From: Doc Hansen
Sent: Monday, July 18, 2016 3:33 PM
To: Rose Shriner
Subject: RE: SX-16-00008

From: Rose Shriner
Sent: Monday, July 18, 2016 12:27 PM
To: Karen Hodges
Subject: SX-16-00008

If you could look this over [\[Holzer Shoreline Exemption\]](#) I would appreciate it. Mr. Holzer wants to repair his fence which is in the floodway, which typically isn't allowed. I was able to find a flood permit for repair work on the bridge, allowing it under the condition that a flood engineer determines that the work does not change or impact the floodway.

TAX PARCEL 17-17-15010-0002
9982 MANASTASH RD
Plot Plan
SCALE: 20' = 1"
KLAUS HOLZER
206-849-8282 - CELLULAR
509-933-3998-ELLENBURG

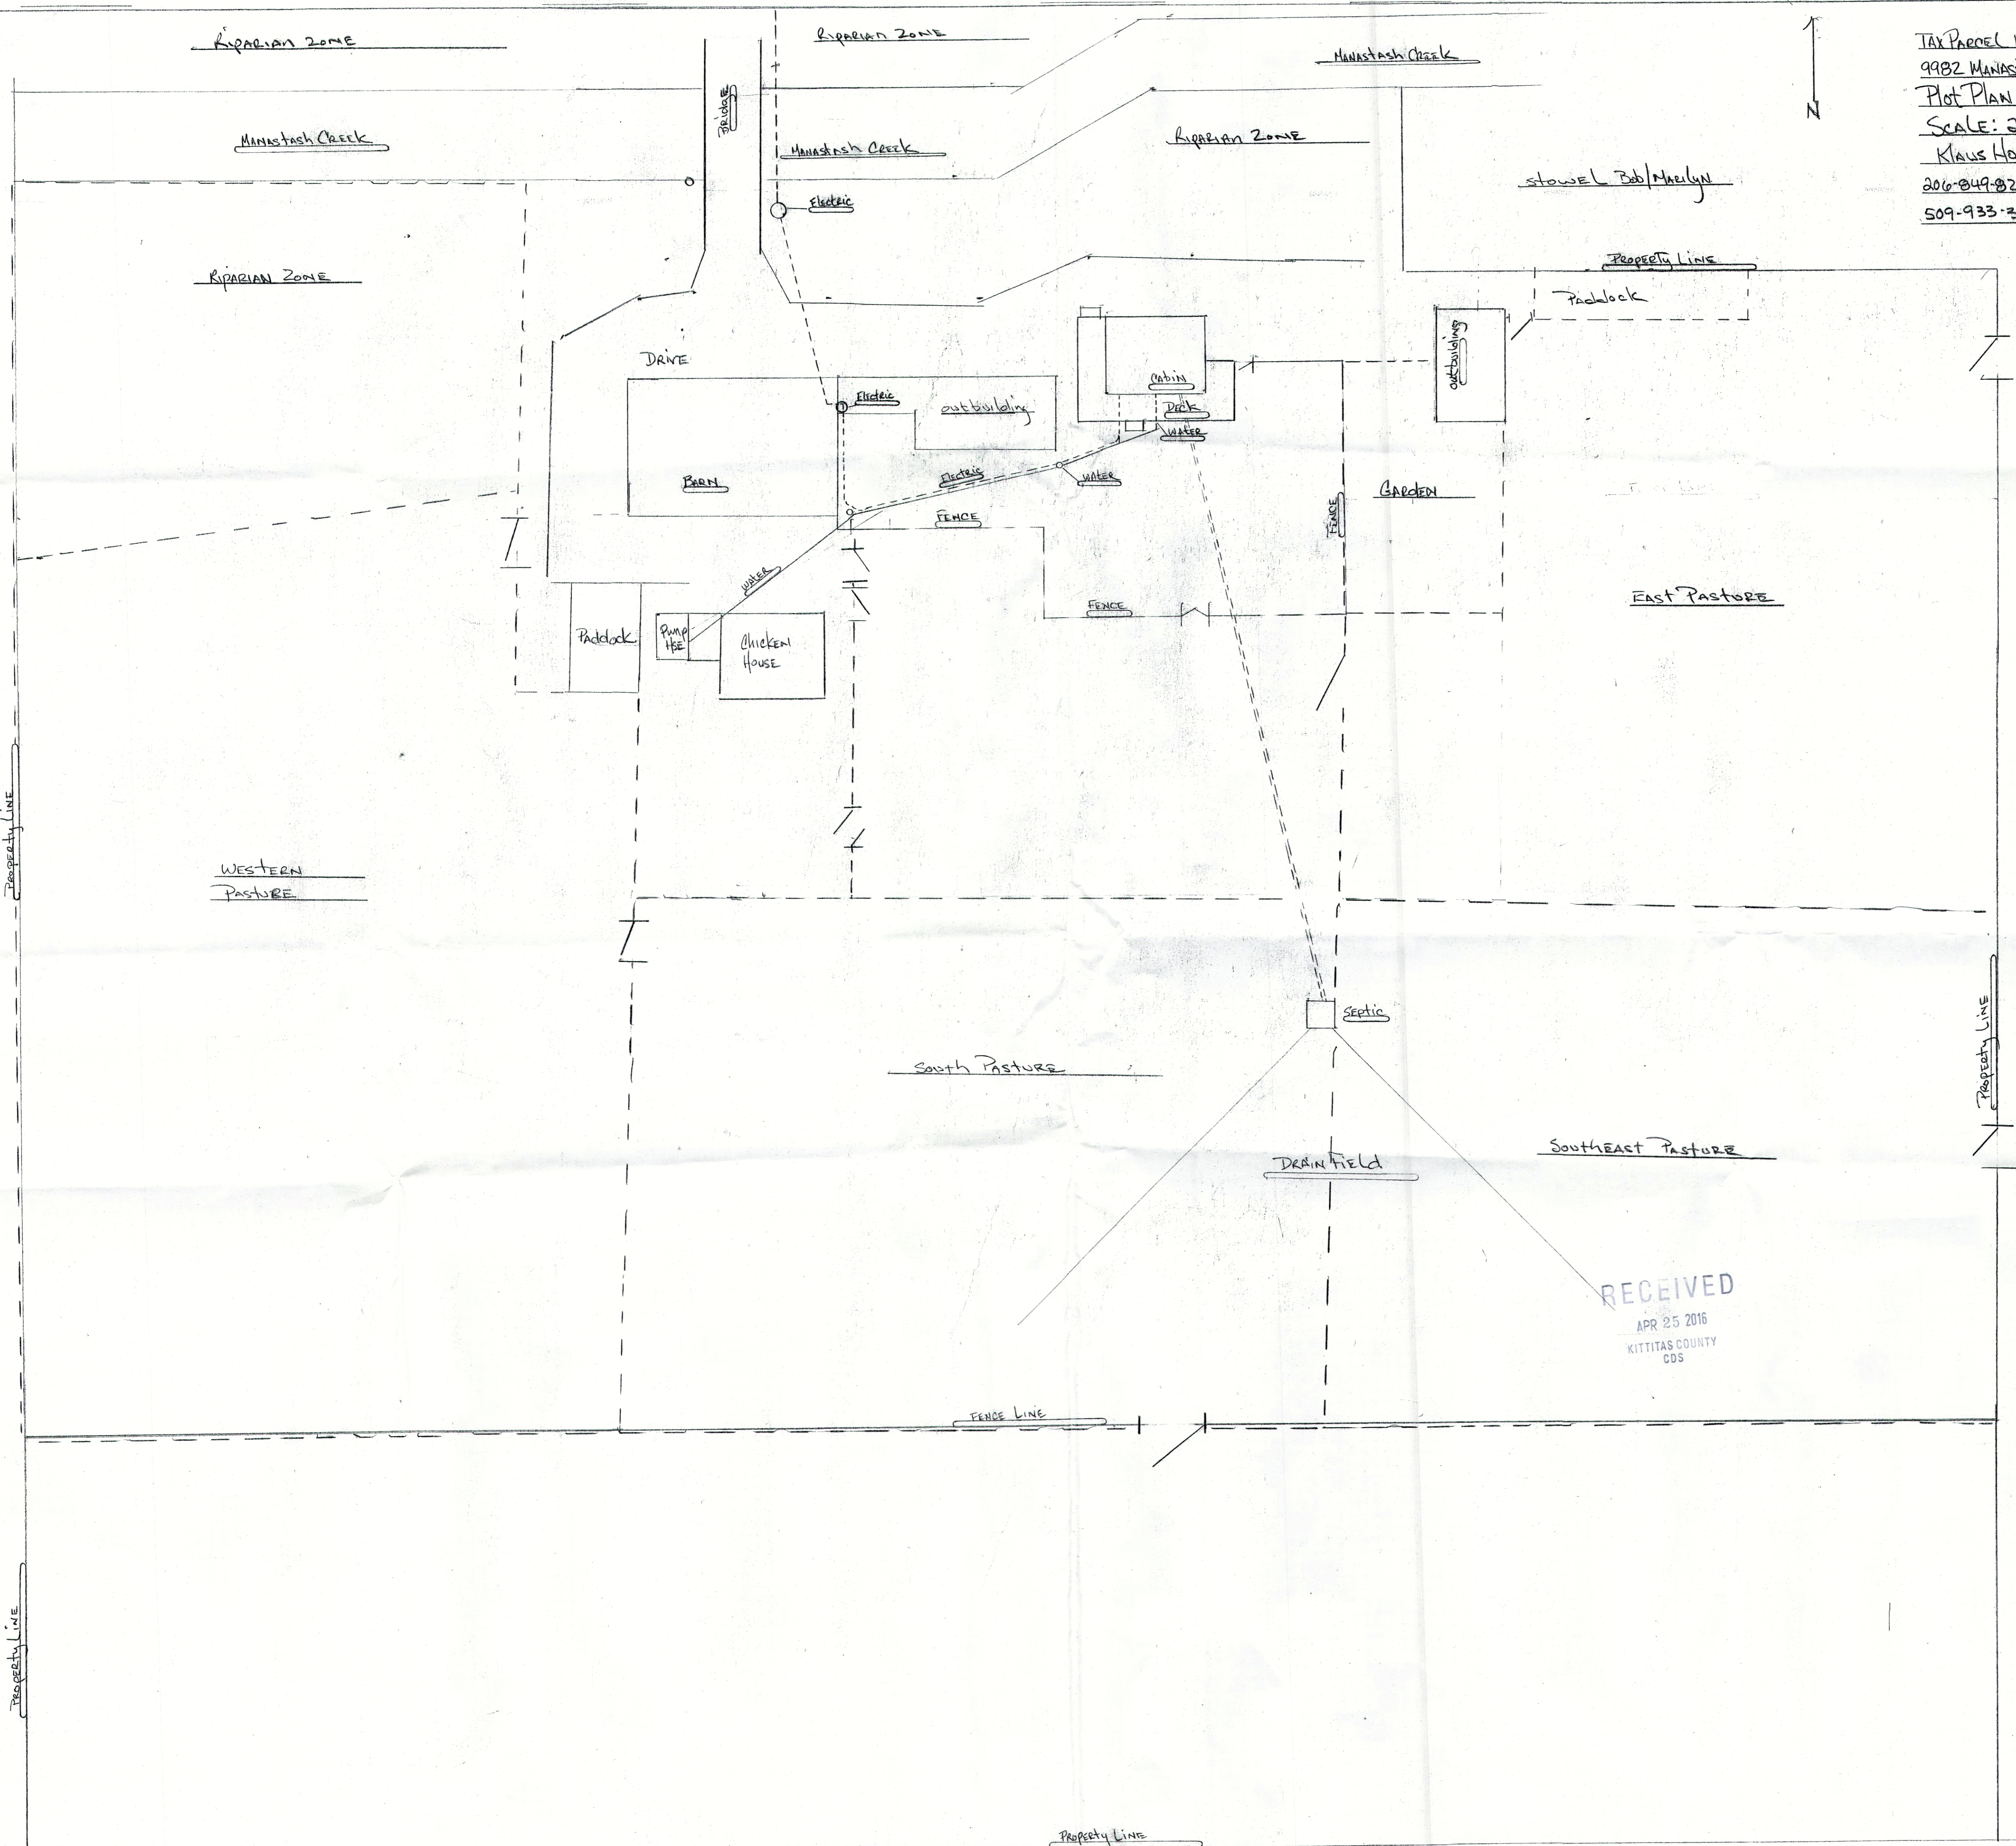
A portion of this property is located within the floodway. The floodway is highly restricted and any development must demonstrate no rise in the level of the 100-year flood before being permitted. No new or substantially improved residences are allowed within the floodway.

I looked over the fence construction plans and feel that they have made a good effort to ensure that there will be no impacts to the floodway as a result of this fence because of the removable panels.
